WEST SUSSEX COUNTY COUNCIL CONSULTATION

TO:	Arun District Council - FAO: Anita Gardner
FROM:	WSCC - Highways Authority
DATE:	15 September 2020
LOCATION:	Langford, Horsemere Green Lane, Littlehampton, BN17 5QZ
SUBJECT:	CM/27/20/DOC Approval of details reserved by condition imposed under ref CM/64/19/PL relating to Condition Nos 3 - materials & finishes, 4 - Construction Management Plan, 9 - pre-commencement site meeting, 19 - foul drainage and 20 - contamination.
RECOMMENDATION:	No Objection

FTA Design HG Right Vehicle (1998)

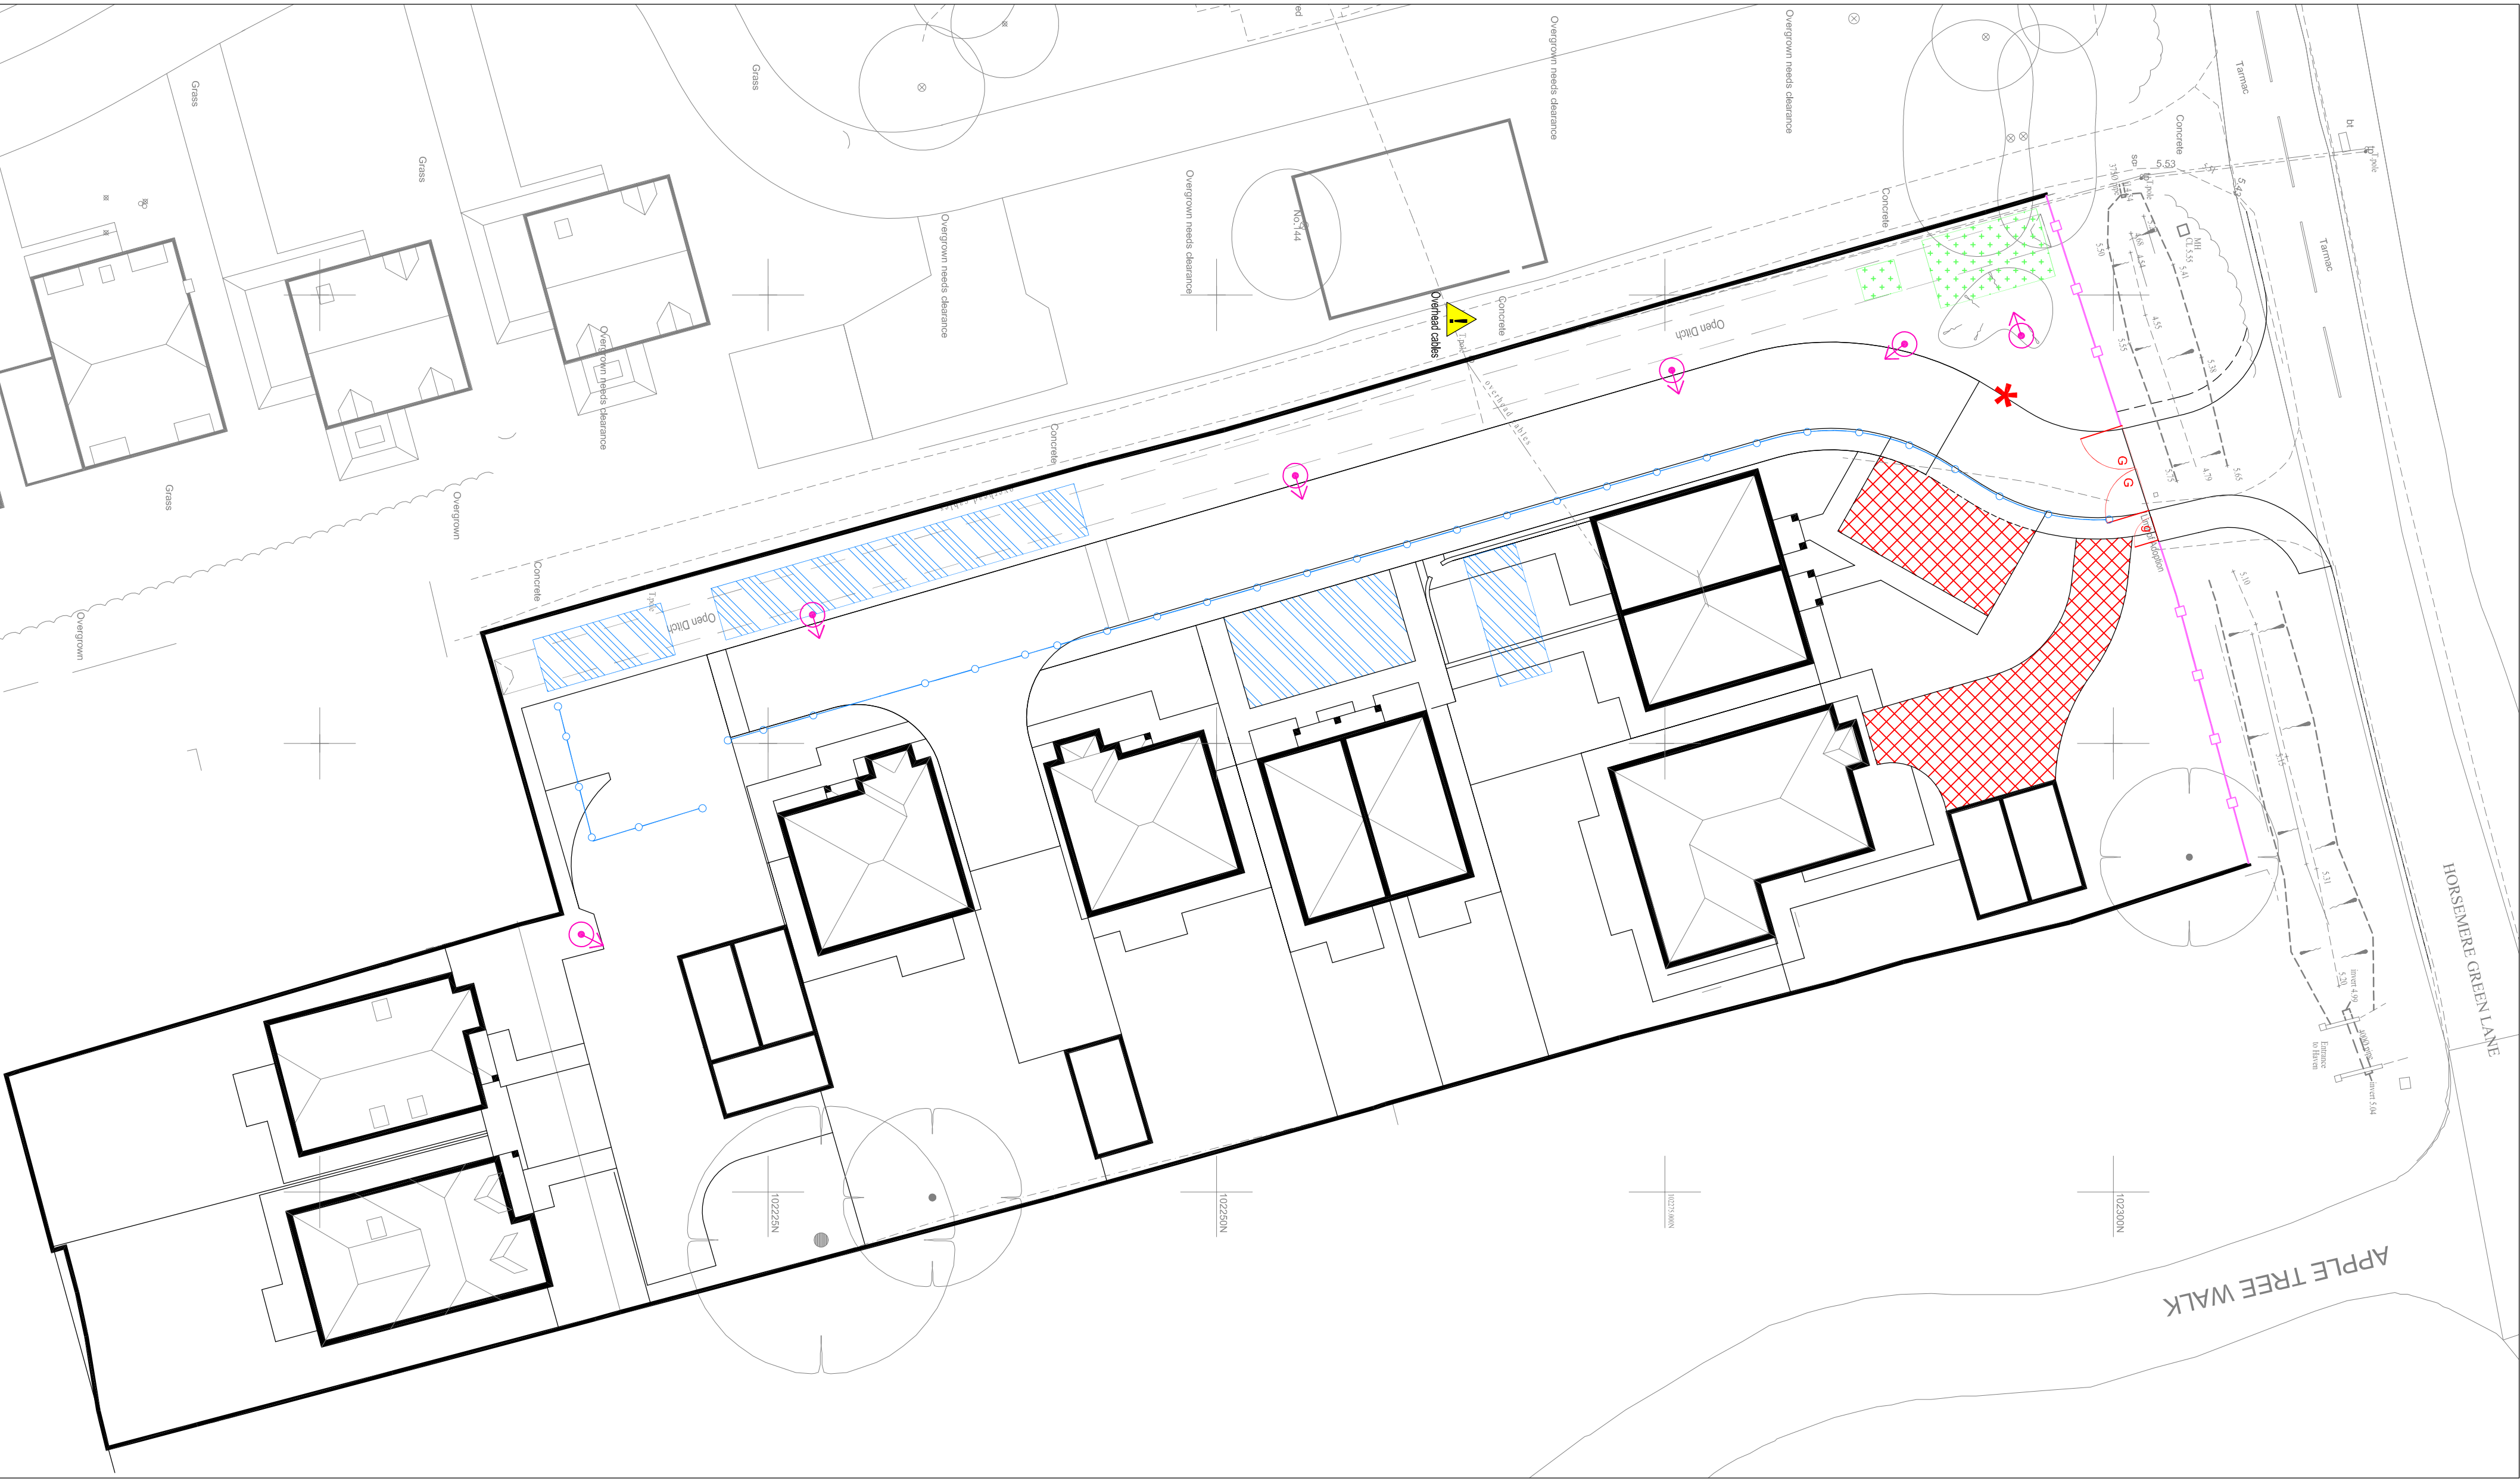
The largest vehicle type anticipated is large flat bed/rigid chassis which will reverse on to site with aid of a banksman. A maximum of 7 x construction vehicle movements per day are anticipated. Once the on-site turning head has been constructed it is expected that construction vehicles will be able to turn within the site. Swept path tracking diagrams show that a rigid vehicle can manoeuvre the access point.

The plans and details pertaining to condition 4 are acceptable.
